Job No. 193940

July 24, 2026

Re: Response to:
Colorado Geological Survey Review Comments, dated December 22, 2025
Triple H Ranch
EPC Schedule No. 3300000168 and 3300000388
El Paso County, Colorado

PRELIMINARY PLAN

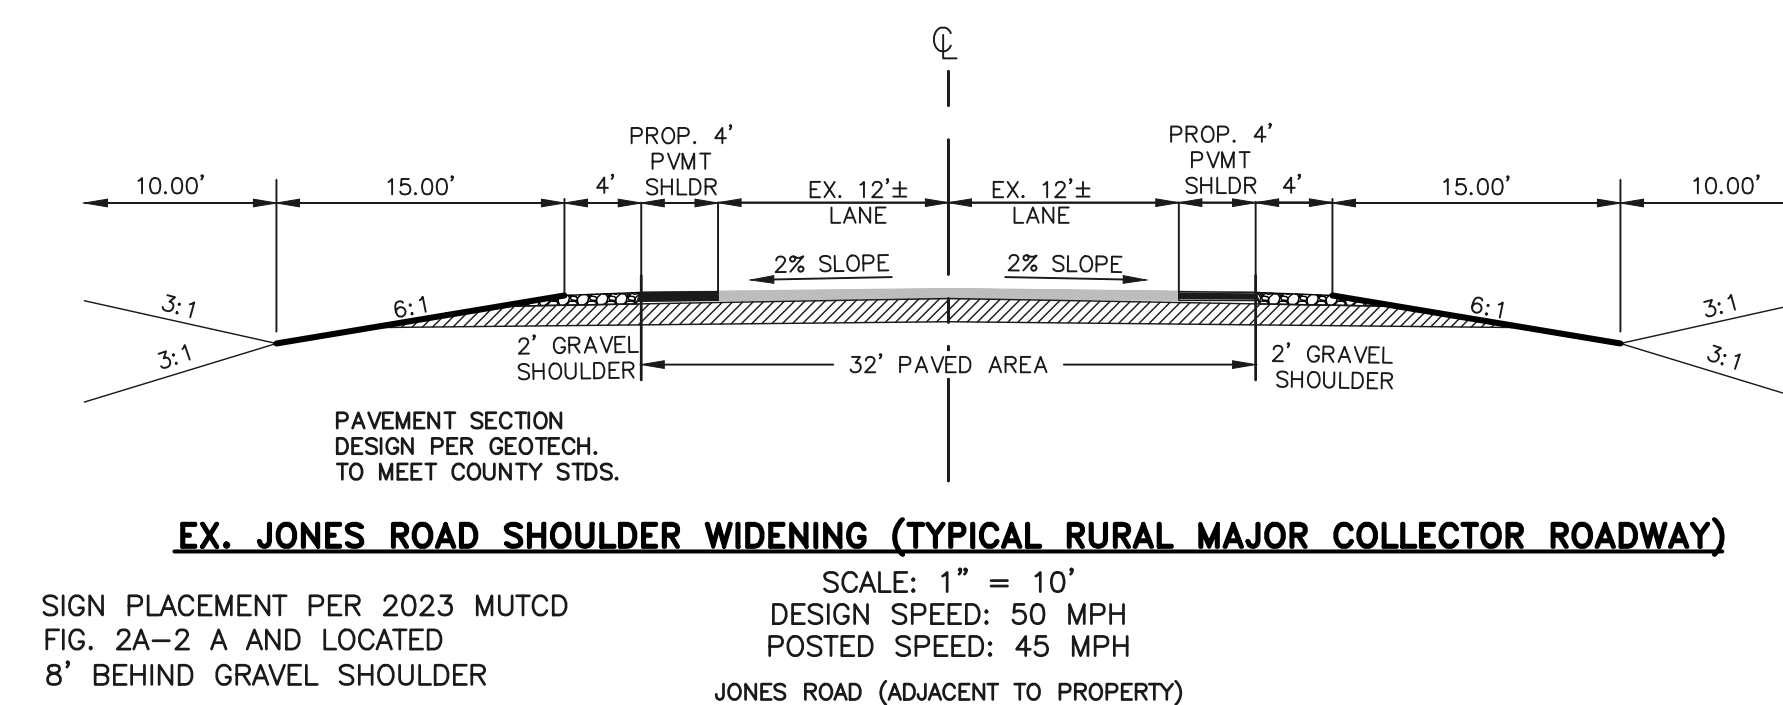
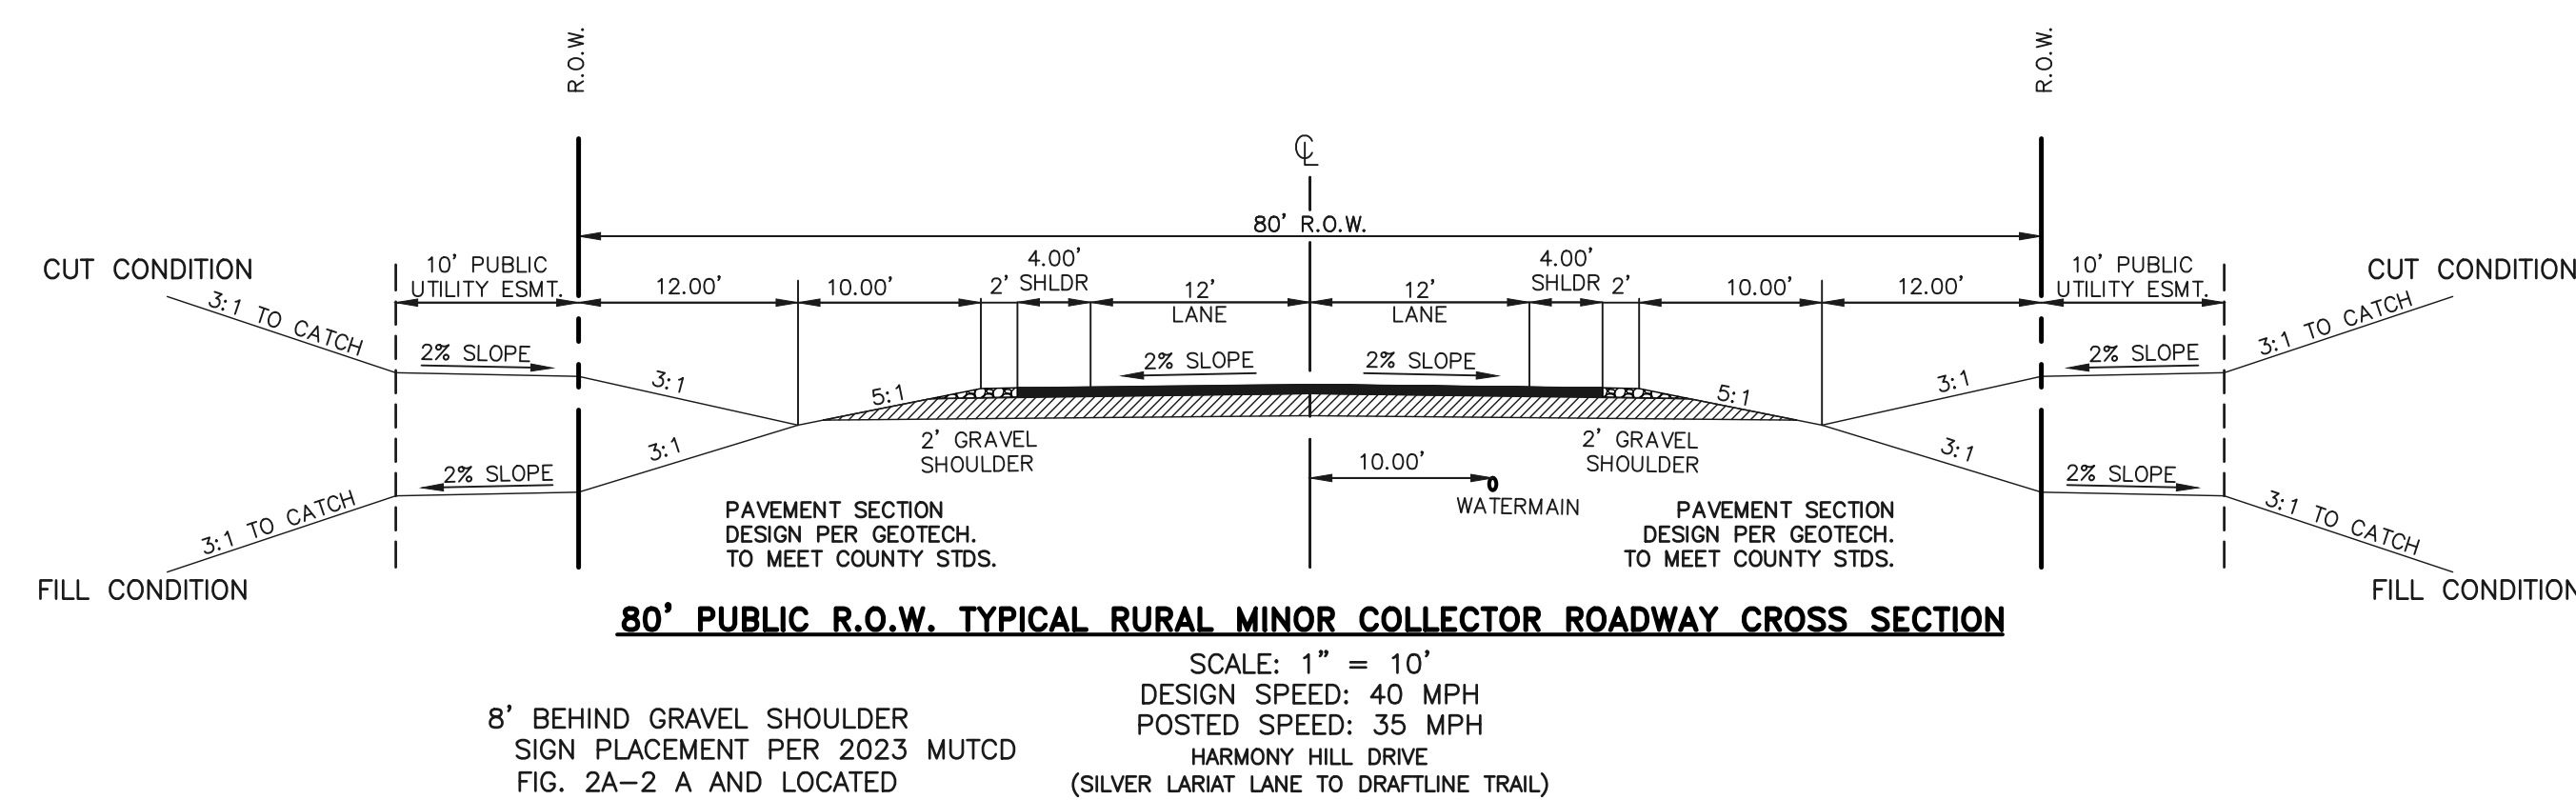
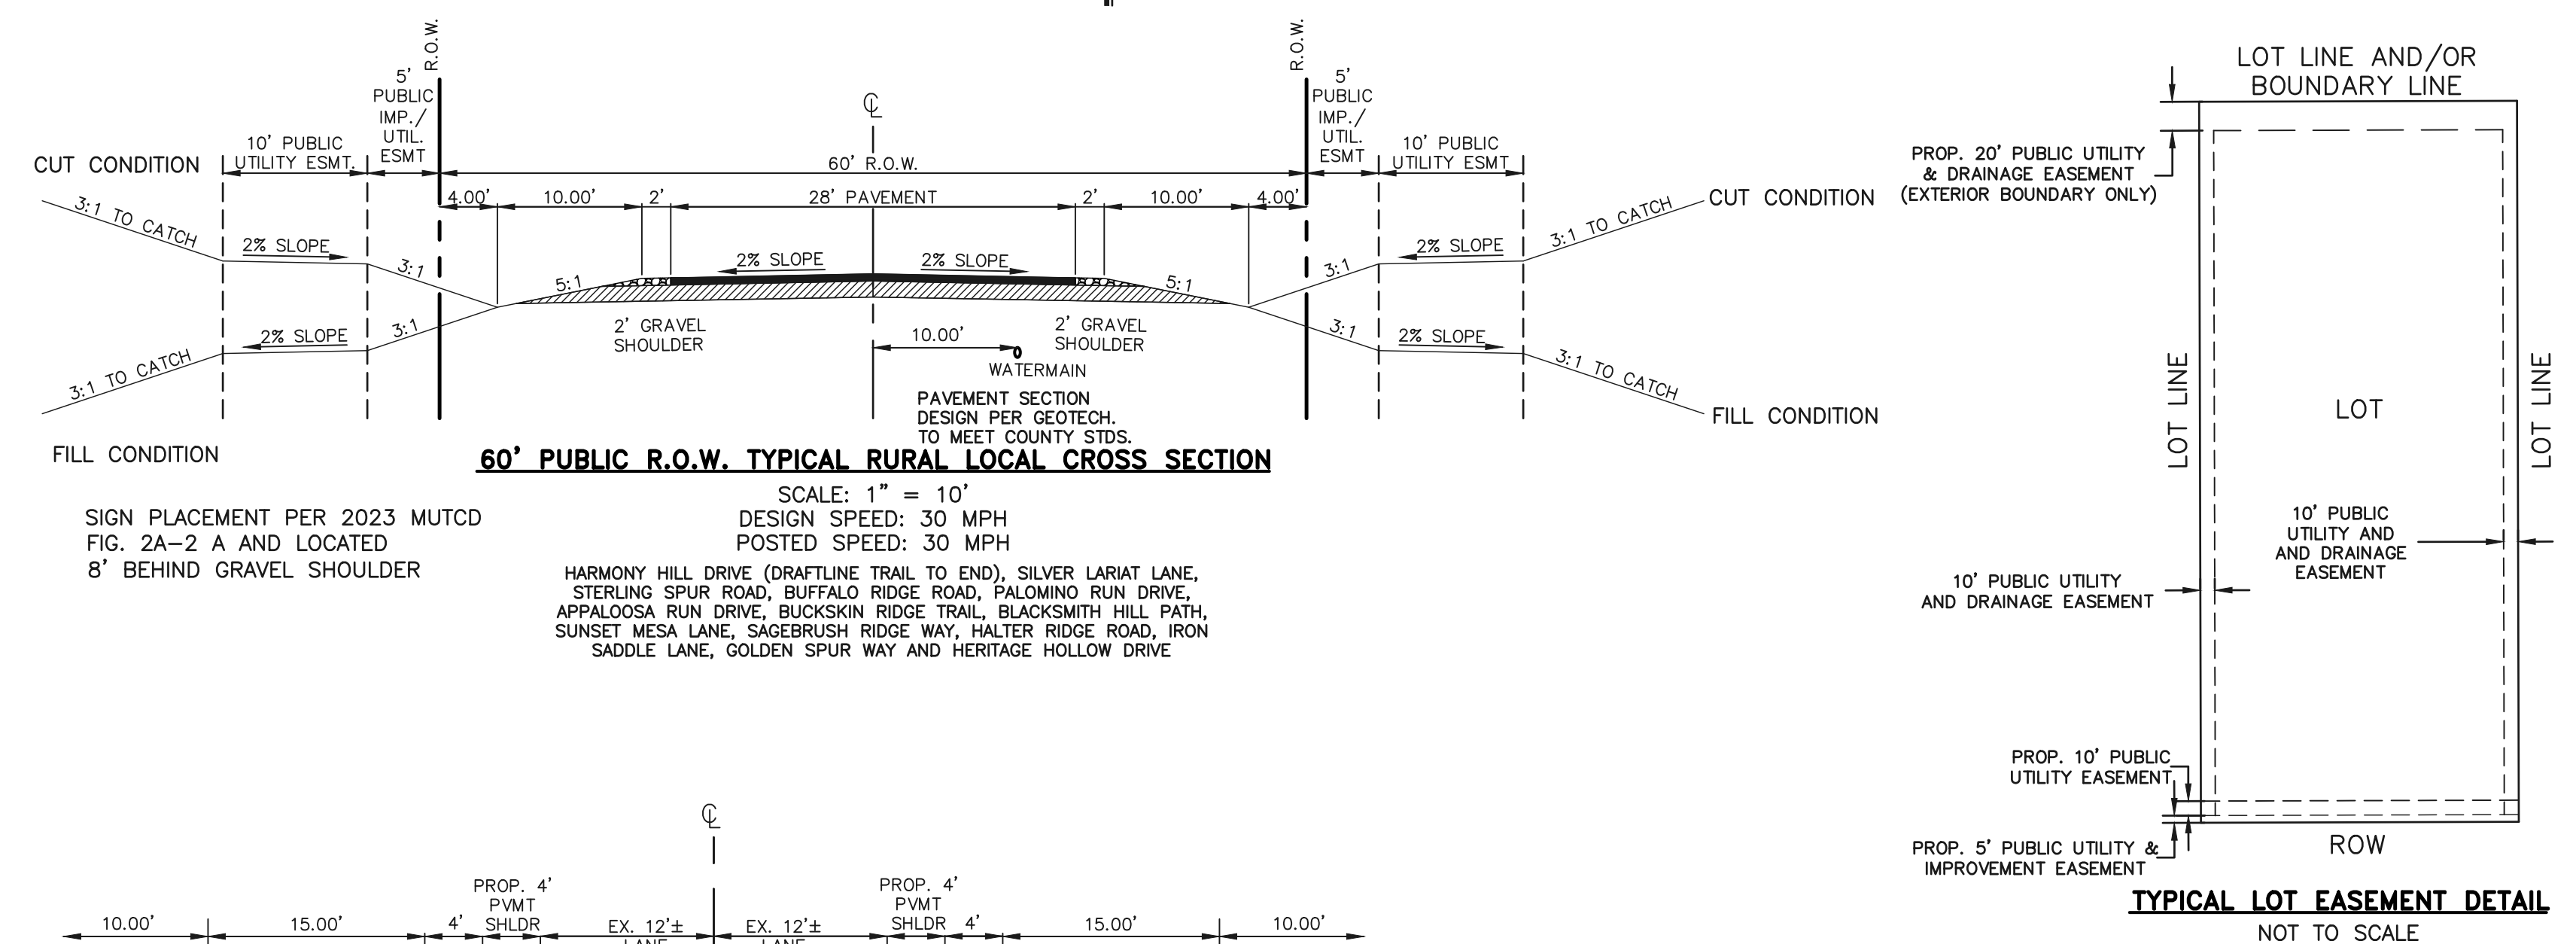
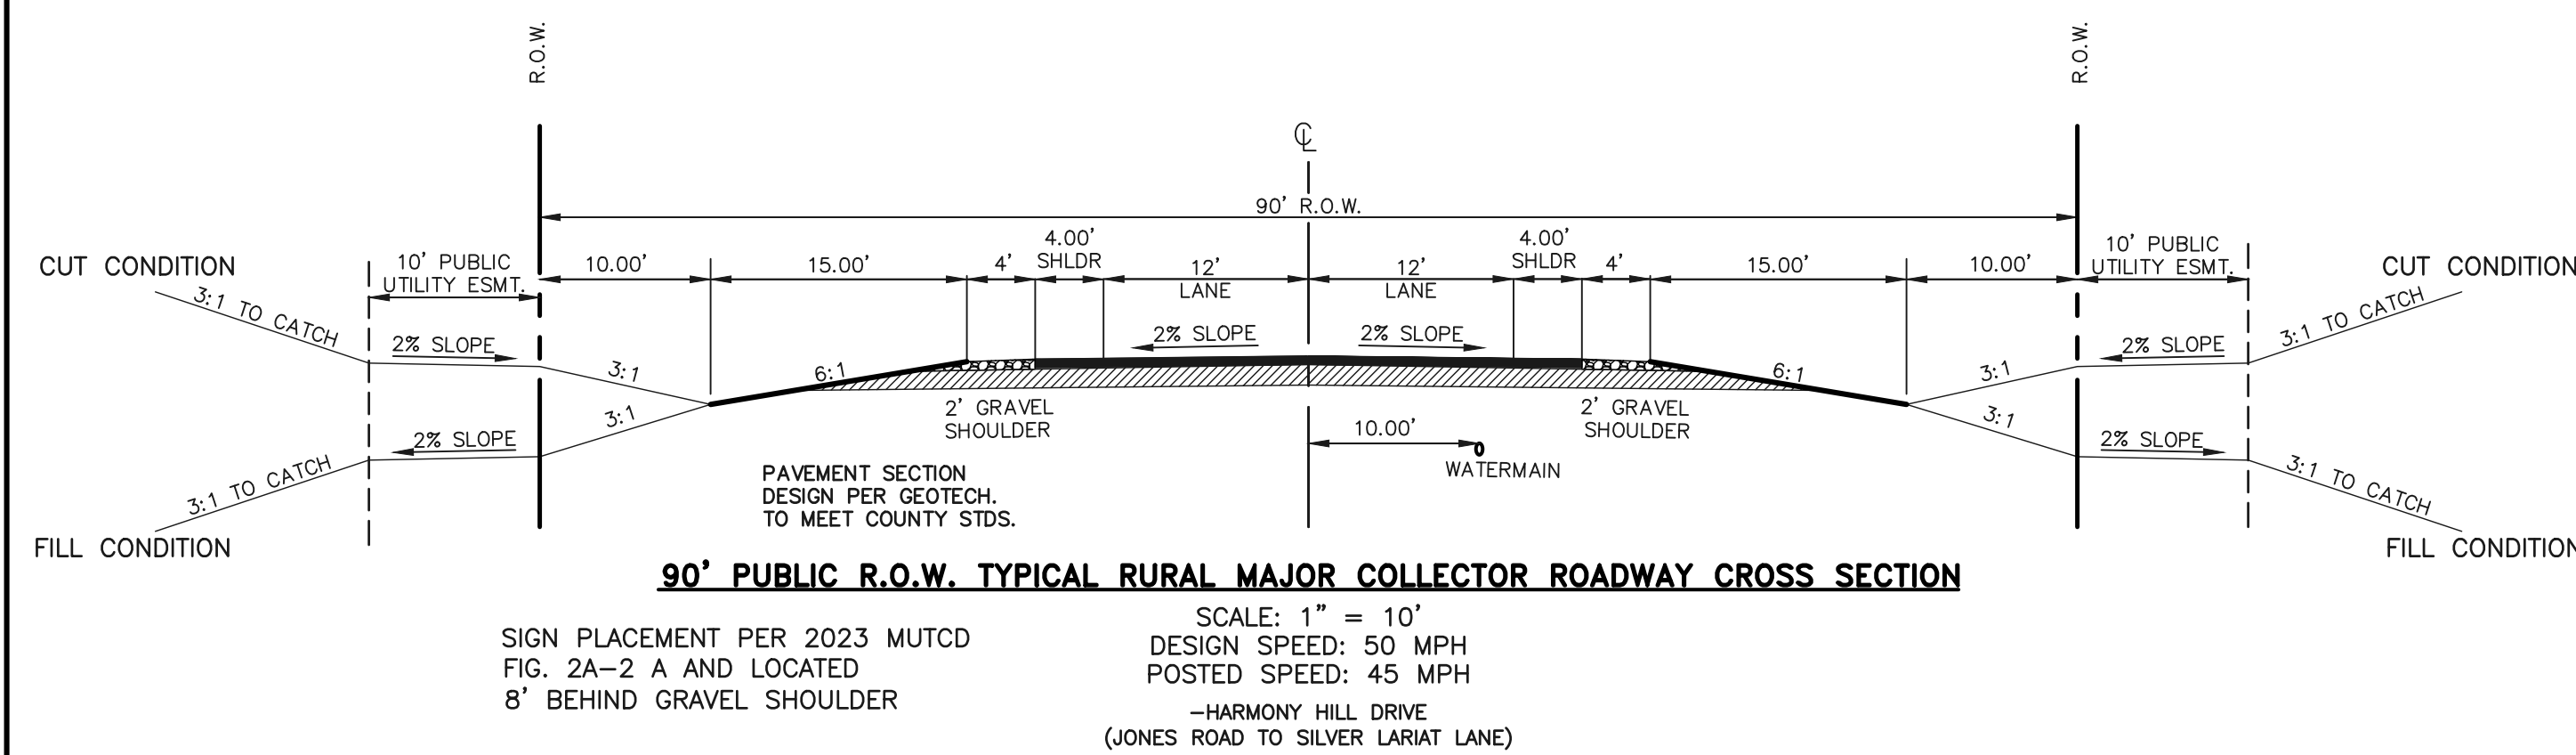
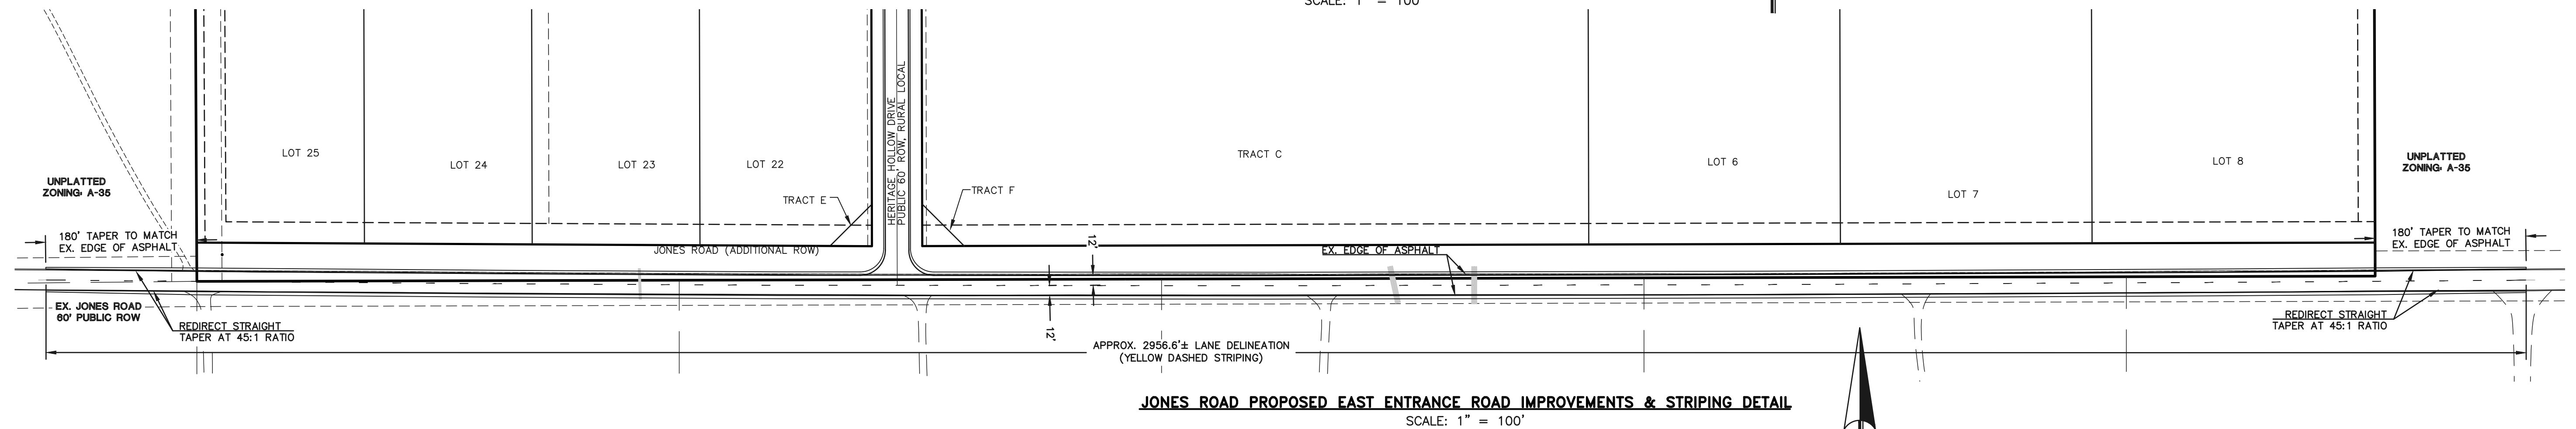
1. The preliminary plan should reference RMG's report for the Triple H Ranch.

2. The Geologic Hazard Note (Note 14) on the preliminary plan should be updated to list all of the geologic hazards associated with the site and mitigation measures.

The preliminary plan reference has been updated to reflect RMG's report last dated July 24, 2026.

The Geologic Hazard Note has been updated on the preliminary plan. The note presented to the Client reads as follows:

SOIL & GEOLOGY, CONDITIONS, CONSTRAINTS, & GEOLOGIC HAZARD NOTES:

A Soil and Geology Study for Triple H Ranch located within El Paso County, Colorado, was completed by RMG Engineers (Job No. 193940), last amended on July 24, 2026. The overall development area has been found to be impacted by the geologic constraints listed below.

- Potentially expansive and compressible soils
- Flood prone area
- Faults and seismicity
- Radon

Due to the size of the lots, mitigation of the identified constraints is most effectively accomplished on a lot by lot basis.

- A site-specific subsurface soil investigation is to be completed for each lot, water tank and treatment building prior to permitting.
- A No Build Zone is located near the southwest corner of the site. The location of the residence and OWTS on Lots 11-16 are to remain outside the No Build Zone.

- A year-long groundwater monitoring program is to be finalized April 2027. To date, groundwater has not been observed. Once the monitoring is complete, the feasibility of basement construction is to be determined.

- Conventional shallow foundations consisting of a standard/spread footing/stemwalls are anticipated to be suitable for the proposed residential structures. A perimeter drain is recommended around portions of the structures which will have below habitable space or storage space located below the finish ground surface. This includes crawlspace areas but not the walkout trench, if applicable.

- Appropriate surface grading and drainage should be established during construction and maintained (over the life of the structure) by the homeowner. Additional mitigation measures can be found in said report, PCD File SP254, available at the El Paso County Planning and Community Development Department.
